Application for approval of details reserved by condition imposed under planning permission EP/59/17/PL (Appeal no. APP/C3810/W/17/3183667) relating to condition No. 9 (Surface Water drainage works) & 10 (Sustainable drainage scheme)

Tudor Lodge 125A Sea Road East Preston

Thank you for your internet representation made on 31st July 2018 which has been recorded as '**an objection**' with the comments as follows:

L2340-C-52-750 – Drainage for Planning

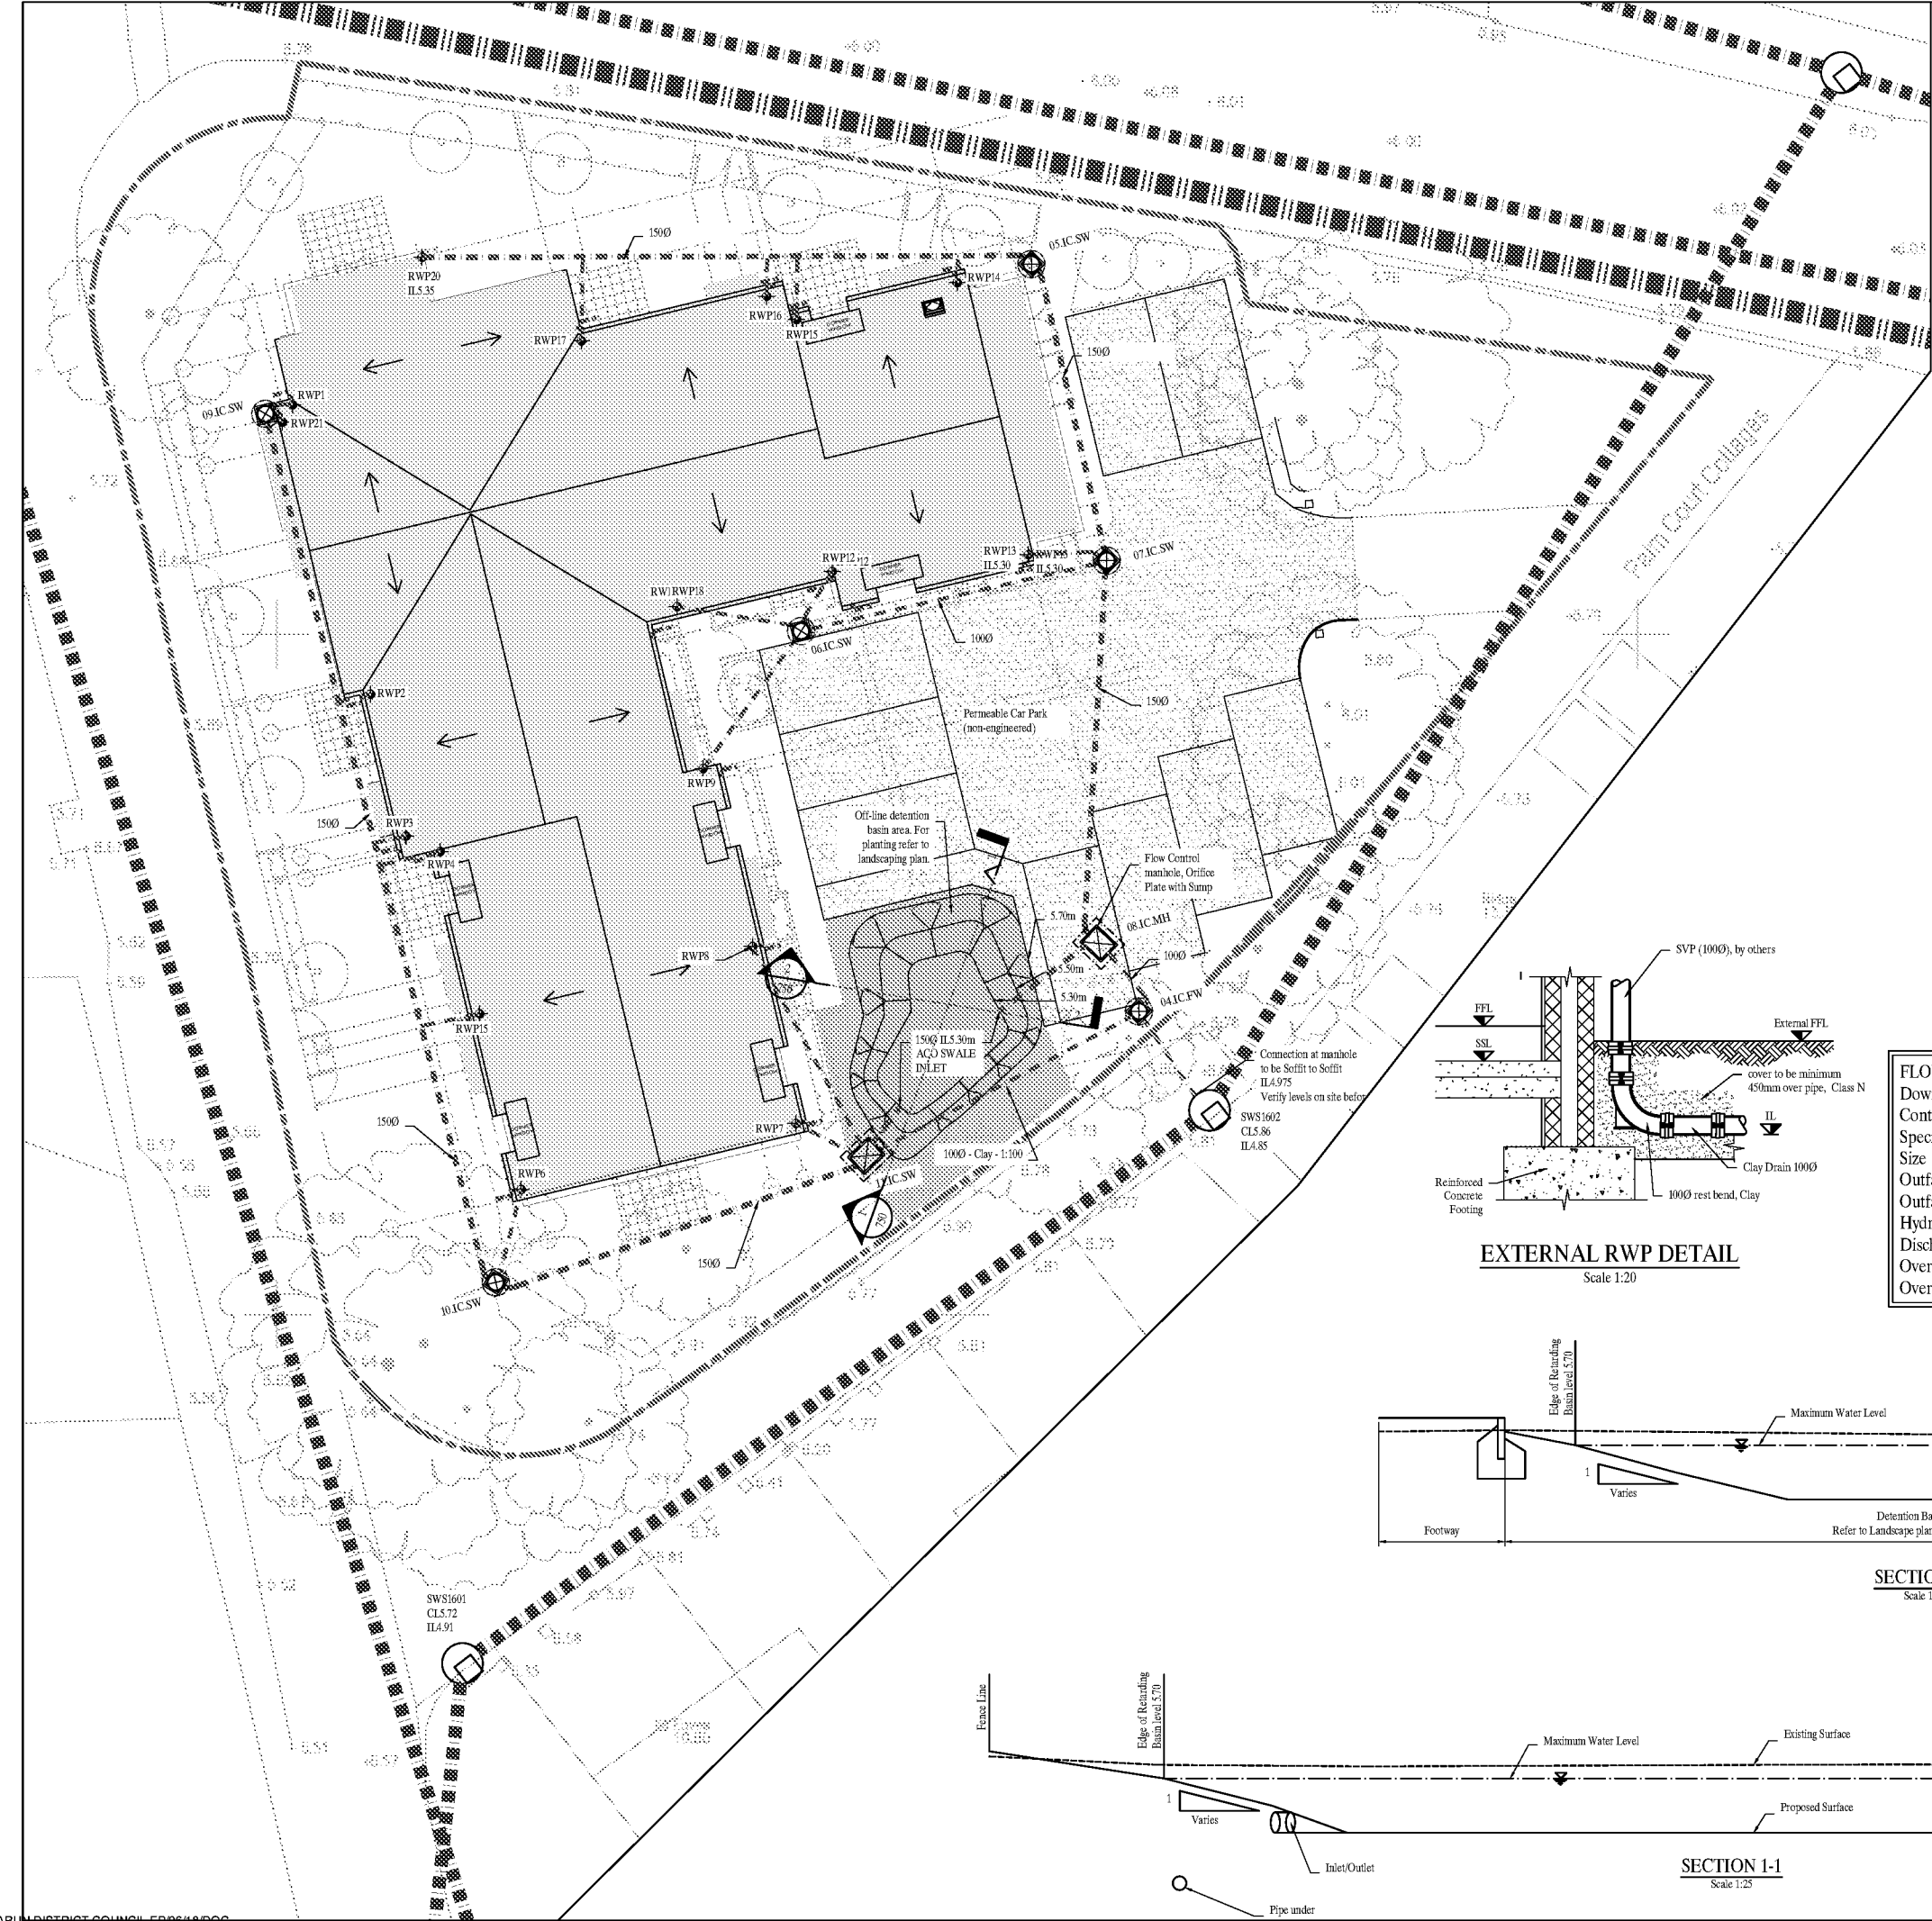
I am writing to object to this proposed application to join the drainage system from Tudor Lodge to Palm Courts drainage system.

The drainage/ sewer system at Palm Court can just about cope with the cottages let alone another 7 properties.

Due to the very old sub-standard drainage and sewer pipes connecting to all of Palm Court In the past few years the residents of Palm Court have all suffered with blocked drains and sewer pipes with it sometimes causing a back up into houses.

Also as I understand that the developers of Tudor Lodge have rights of passage along Palm Court but they do not have the authority to excavate the privately owned land in Palm Court to connect to the sewer.

Why is it not possible to connect the water drainage system to the existing one on Tudor Lodge?
